Request for comments regarding (SSD – 9138102) for the proposed Westlink Industrial Estate at Kemps Creek

Thank you for the opportunity to provide comments on the proposed State Significant Development (SSD-9138102) at No's 59 – 62 Abbots Road & No.63 Abbots Road, Kemps Creek also known as the Westlink Industrial Estate.

Attachment 1 – Detailed comments on SSD – 9138102

# Landscape Areas

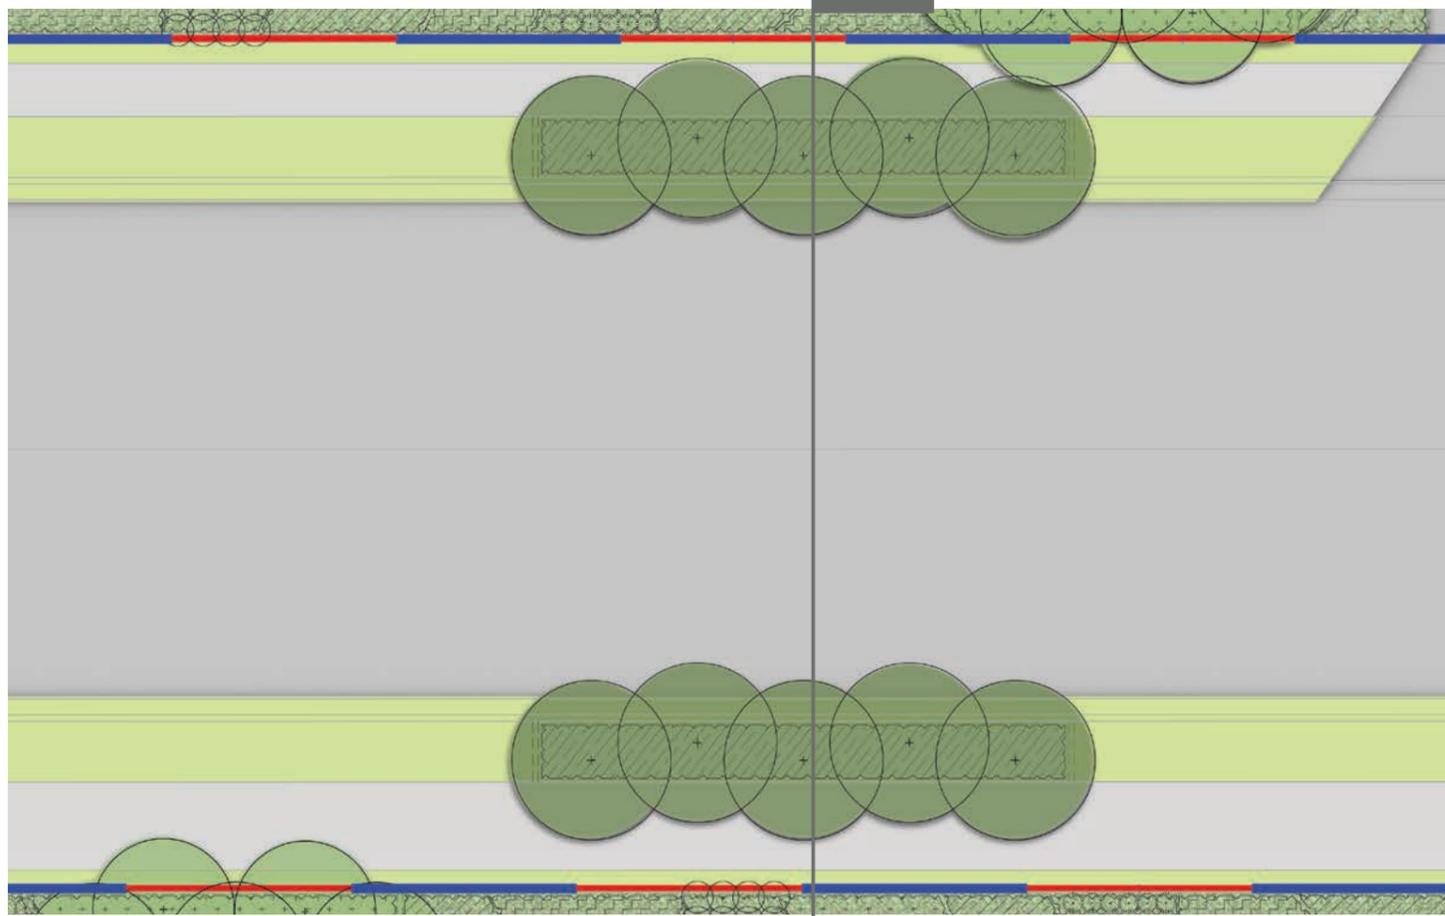
The site is within the 8 km wildlife buffer zone on the Wildlife Buffer Zone Map of the SEPP and careful consideration must be given to any proposed vegetation or landscaping to minimise wildlife attraction as per Part 3, Clause 21 of the Aerotropolis SEPP. It is also noted the proposal will not penetrate the obstacle limitation surface.
